Thank you for consulting Sport England on the above planning application.

Sport England note that there have been several applications in respect of this site, the most recent being 19/01000/OUTMAJ to which Sport England objected. In consideration of the information submitted as part of this latest application (20/01296/OUTMAJ) Sport England note that no amendments have been made to address previous concerns raised.

| Drawn SL | TITLE SALES DRAWING FOR STANDARD BALLSTOP FENCING |

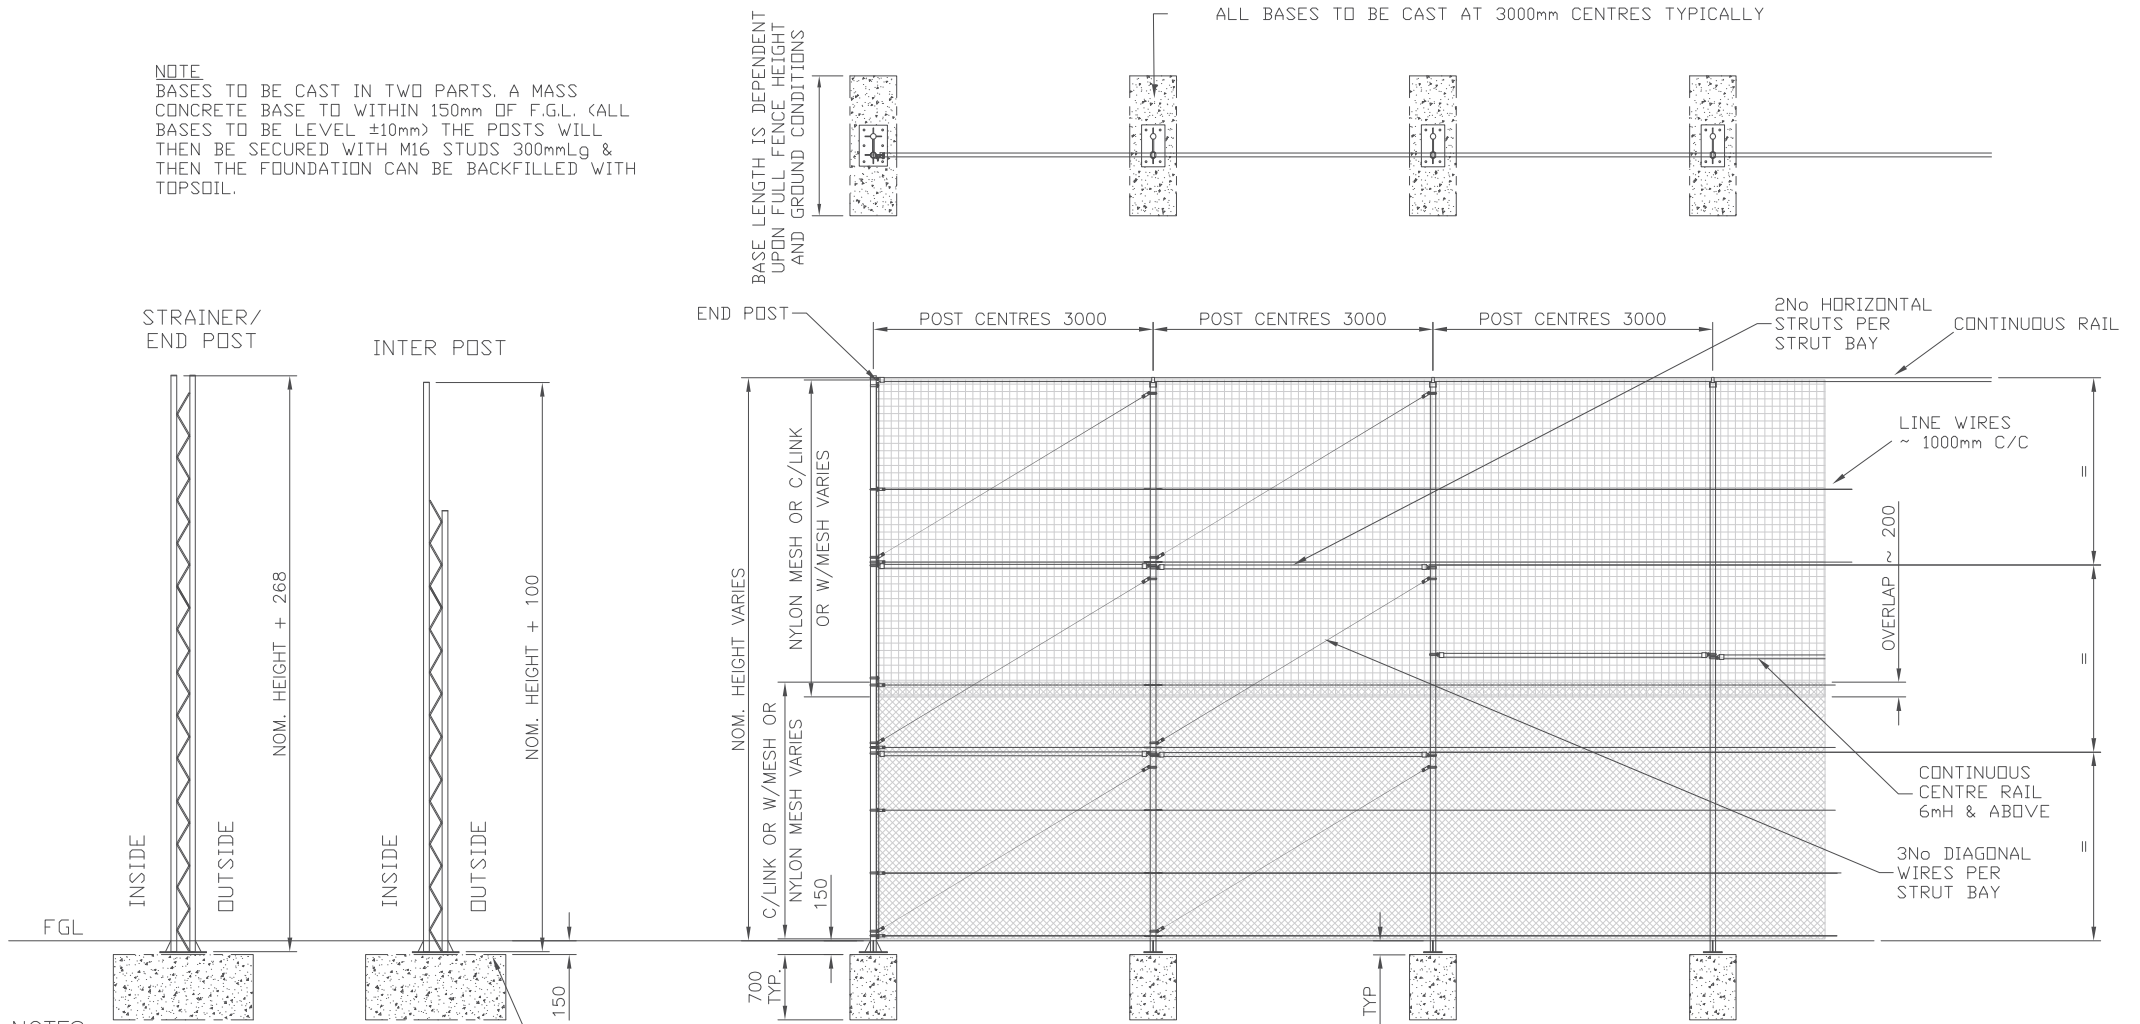
1. A specification has been supplied as part of this consultation which is a □Sales Drawing for Standard Ball Stop Fencing□. ECB would therefore need to ensure the exact dimensions in terms of height and length are installed in accordance with Labosport UK recommendations.

1. A detailed specification for the ball stop fencing including posts and supporting posts which is consistent with the ball strike risk assessment.
2. Full details of how the proposed mitigation will be managed and maintained by the applicant in perpetuity.

PROPOSED SITE PLAN:
 CLIFTON HOUSE FARM, SCHOOL LANE, FORTON, PR3 0AR

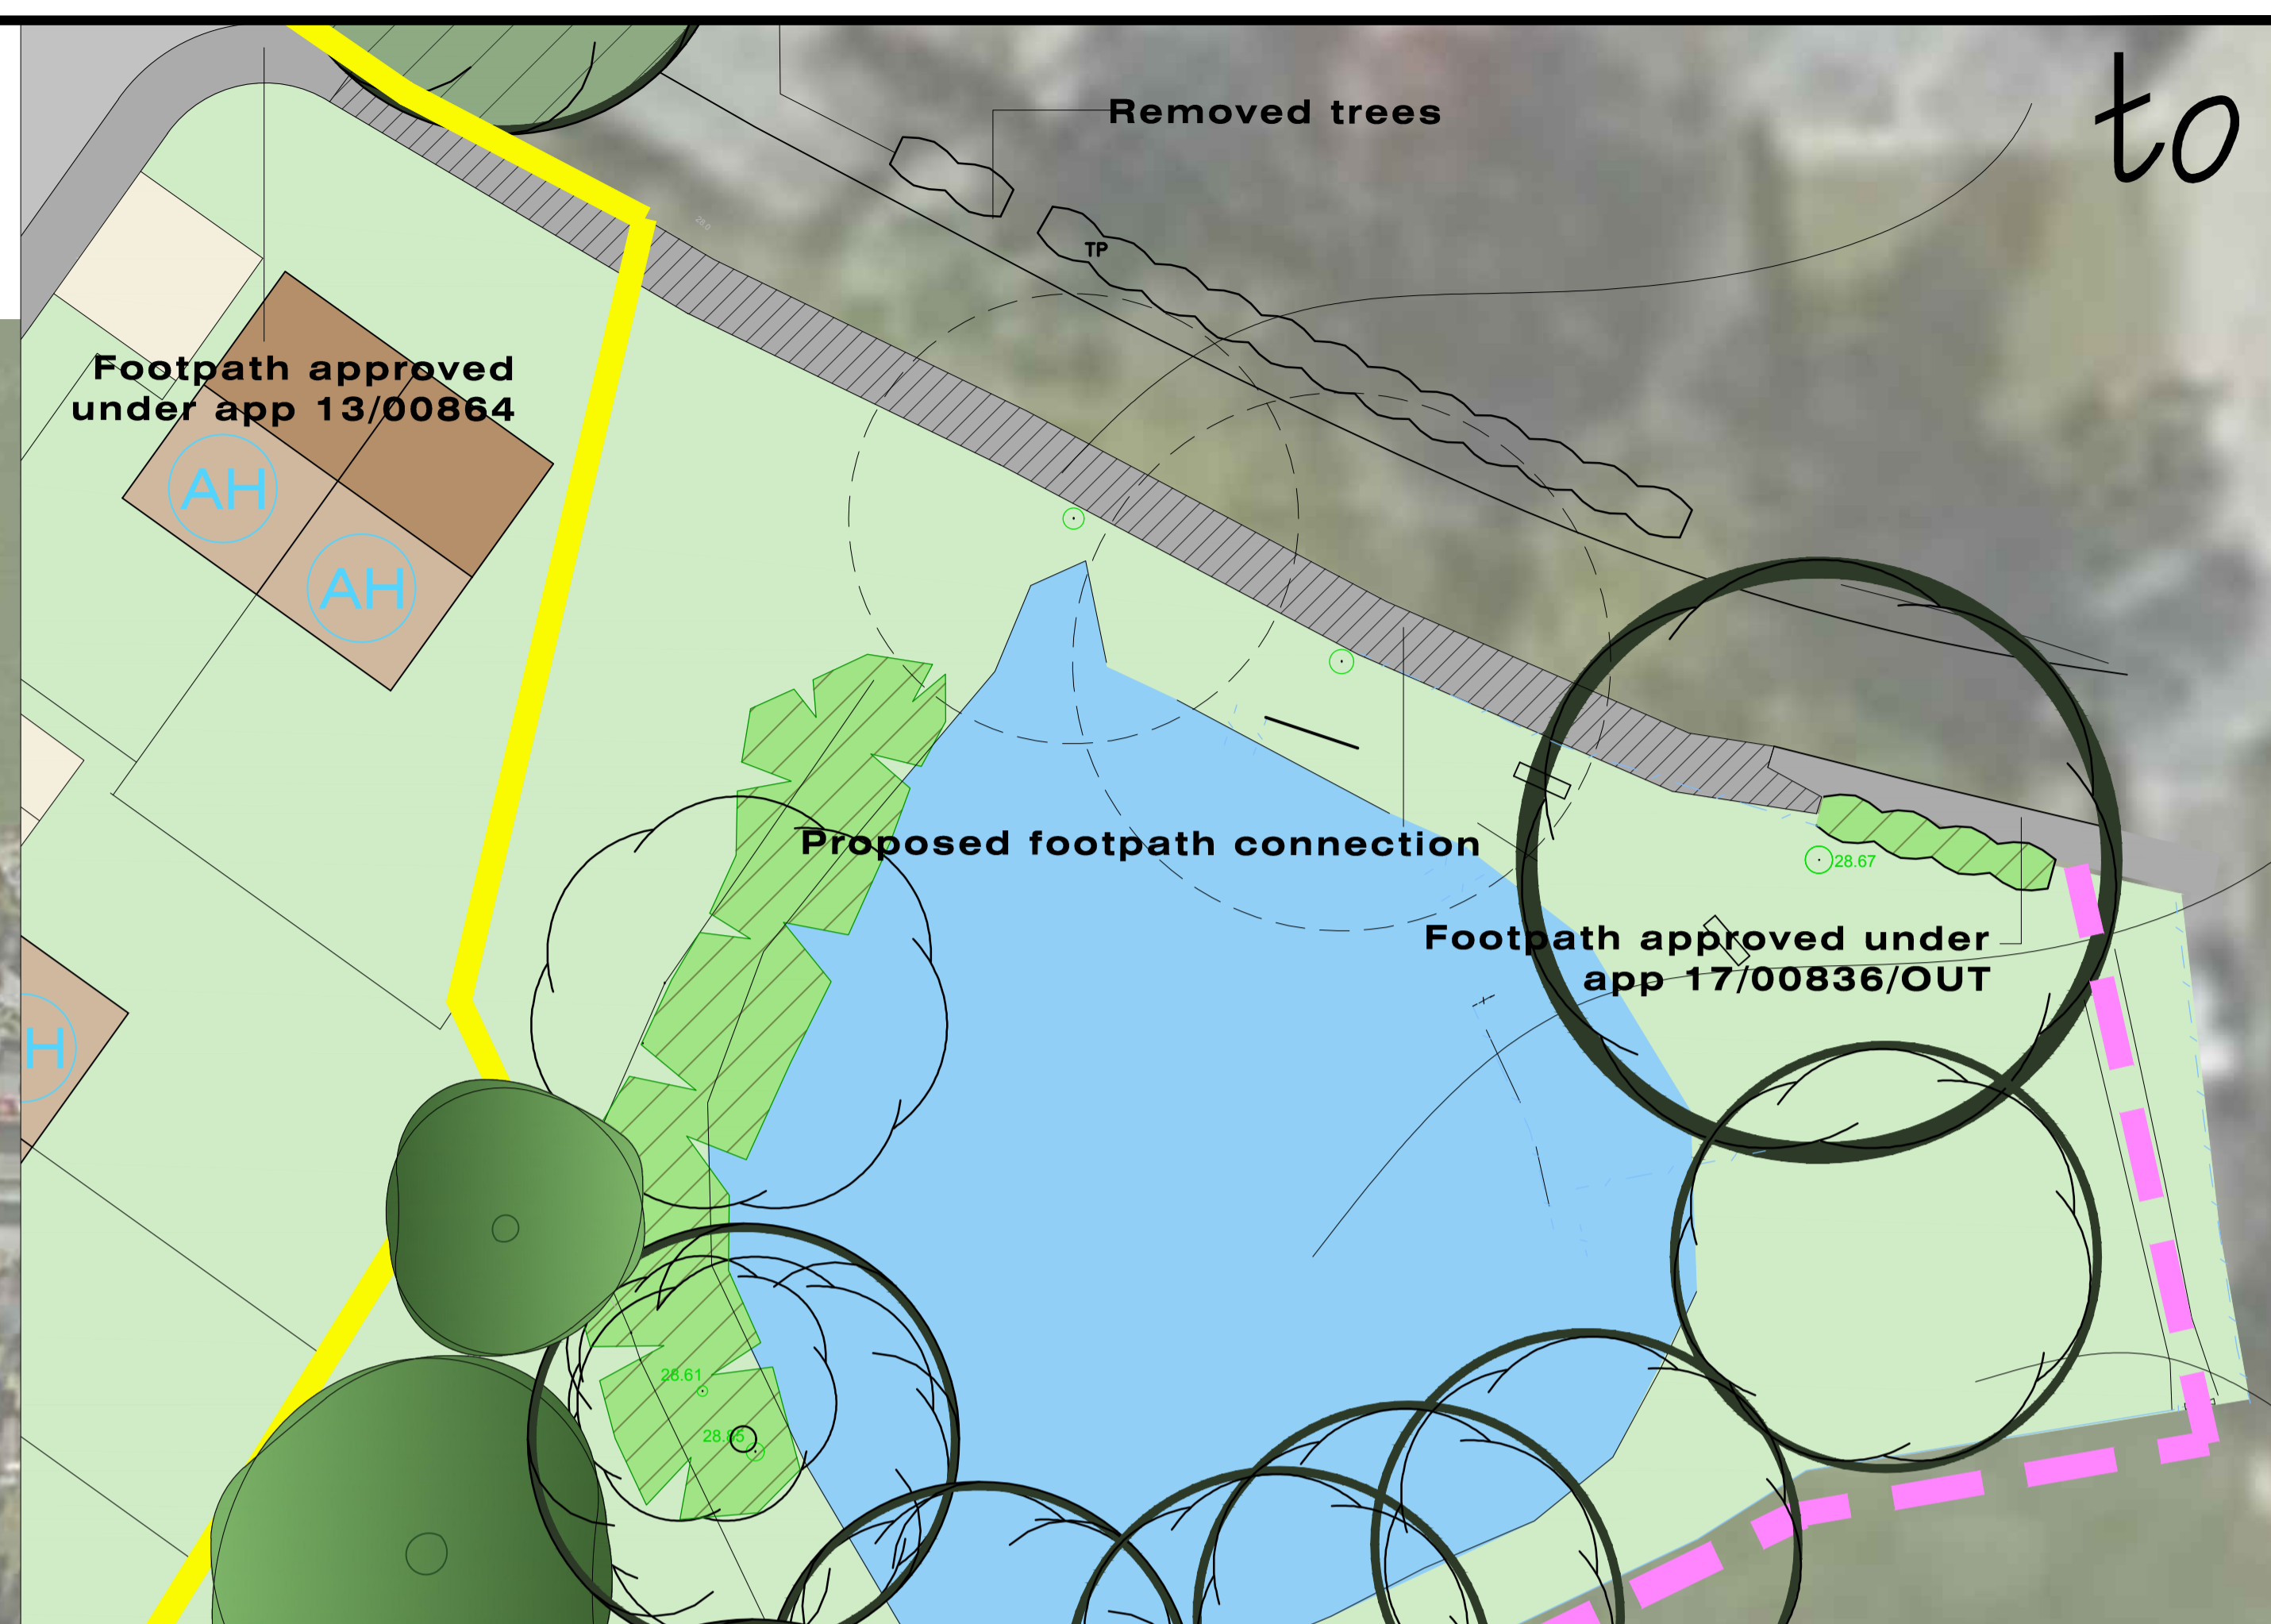
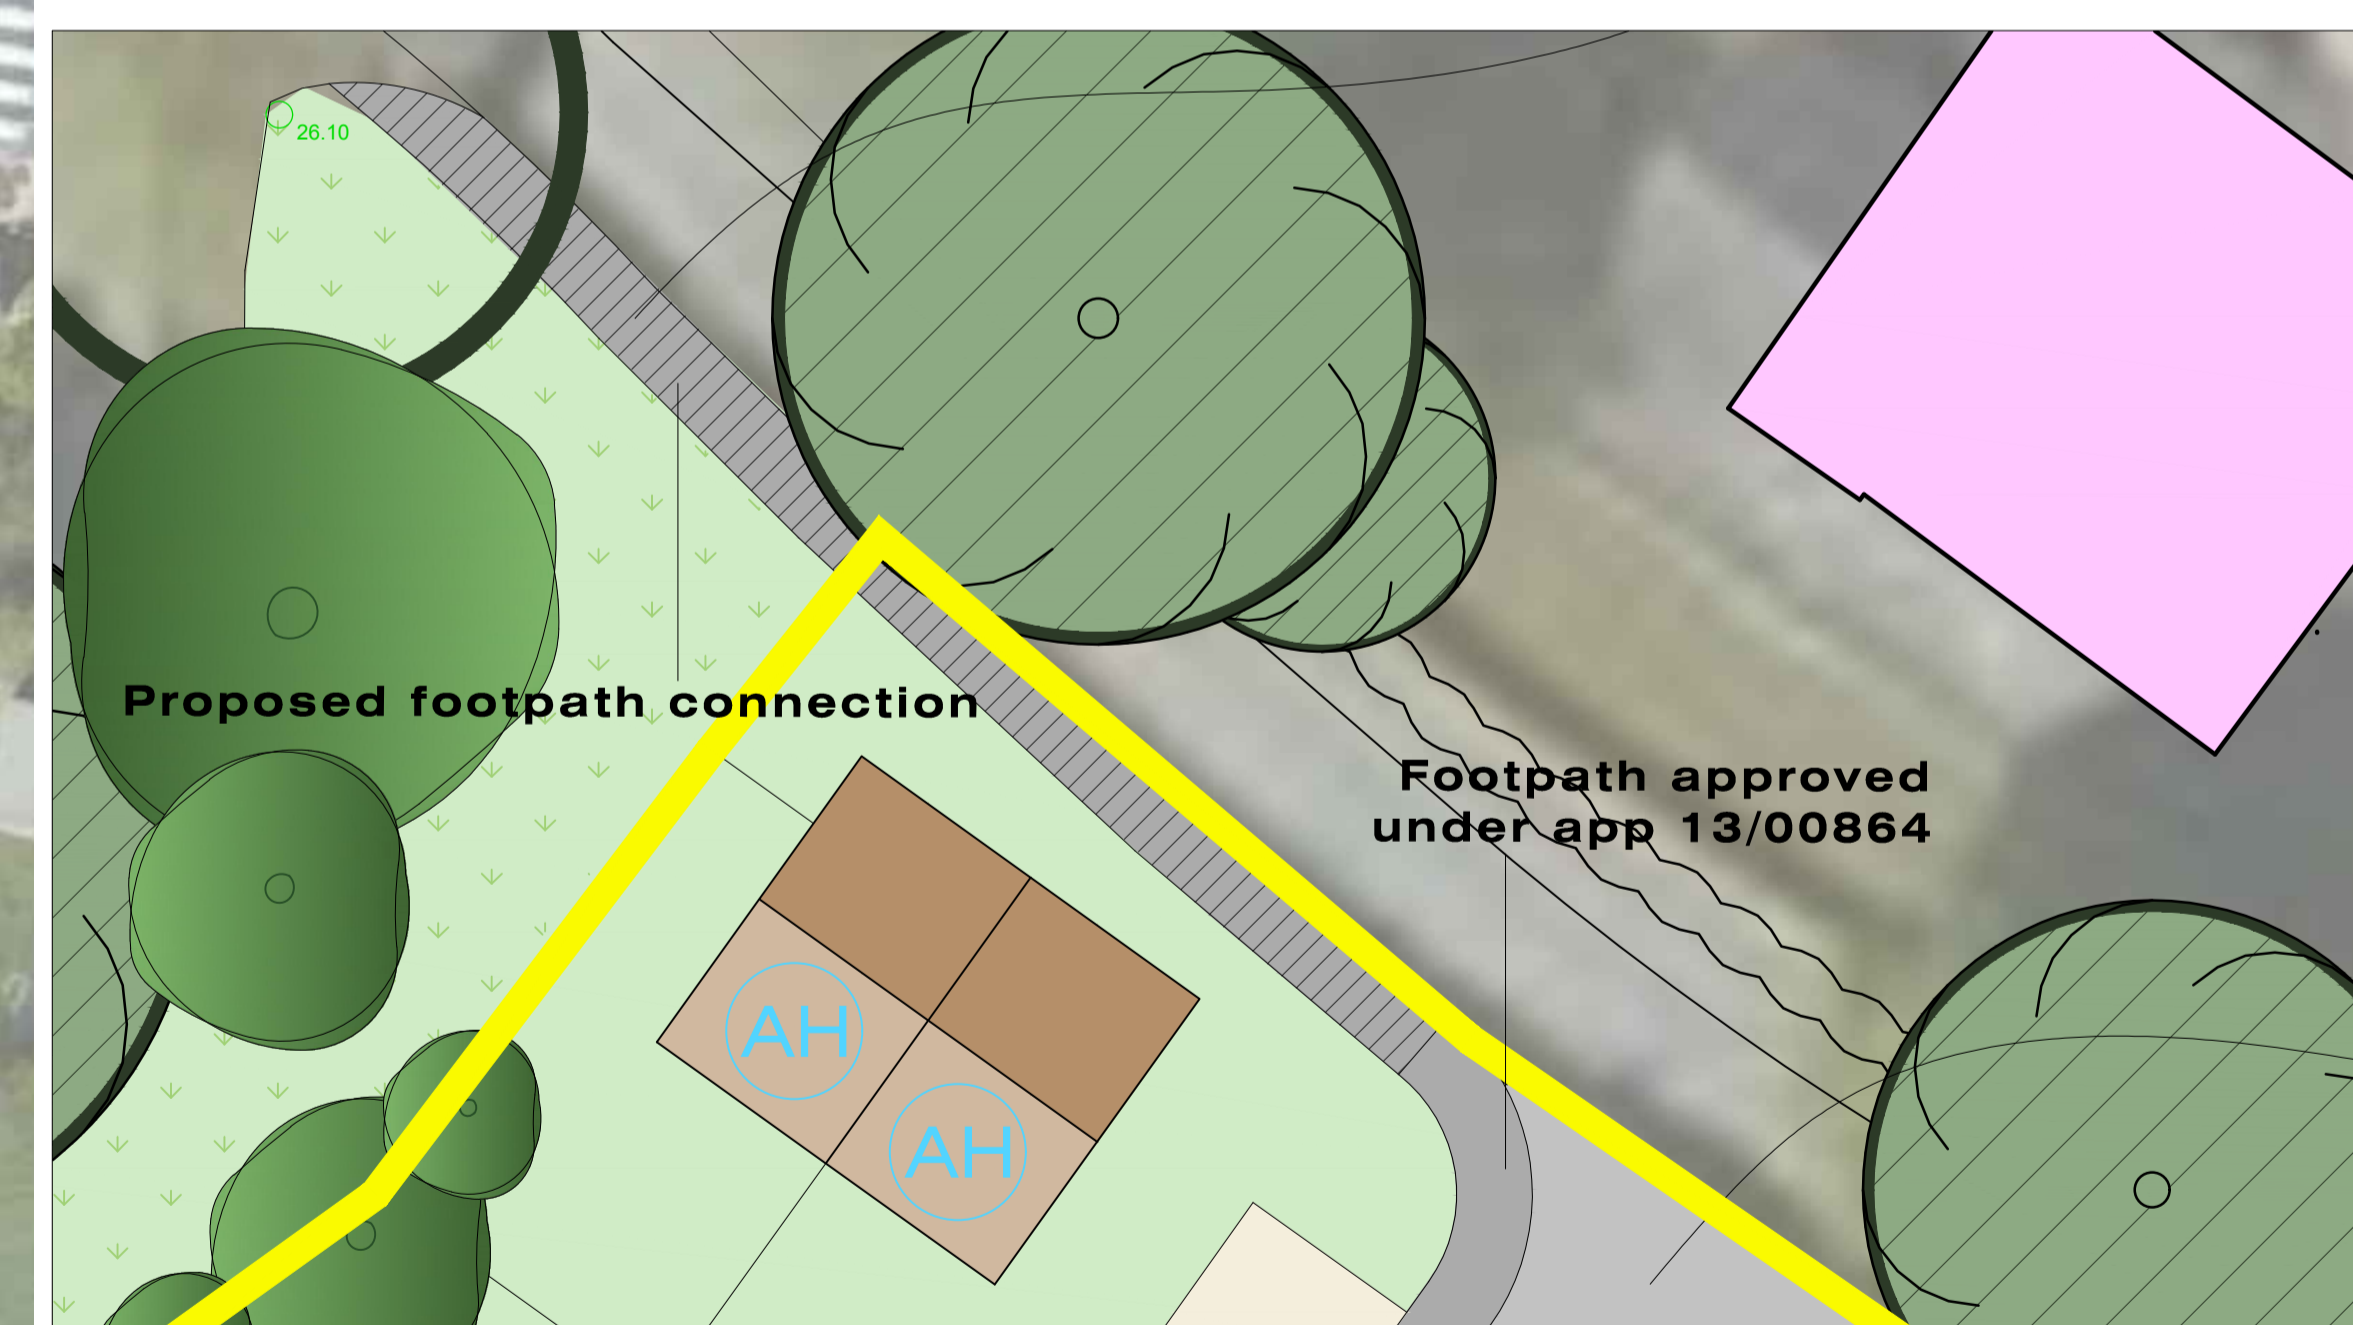
4. Concerns about uncertainty and ensuring an enforceable mitigation/management solution for the buffer area between the protective fencing and the cricket pitch, described as remaining as agricultural land (if that is the end use), whereby protecting this area from risk of ball strike.

3. A management specification for the area described as agricultural land between the ball stop fencing and the cricket pitch. Evidence that this will be maintained and not become garden, public open space or accessible to the public; and evidence of a permanent and enforceable solution to ensure the risk of ball strike in this area in the future is mitigated or avoided.

4. Information about any potential for this land (area described as agricultural to be amalgamated into the cricket pitch whereby people could be prevented from straying into it other than with direct access from within the cricket pitch.
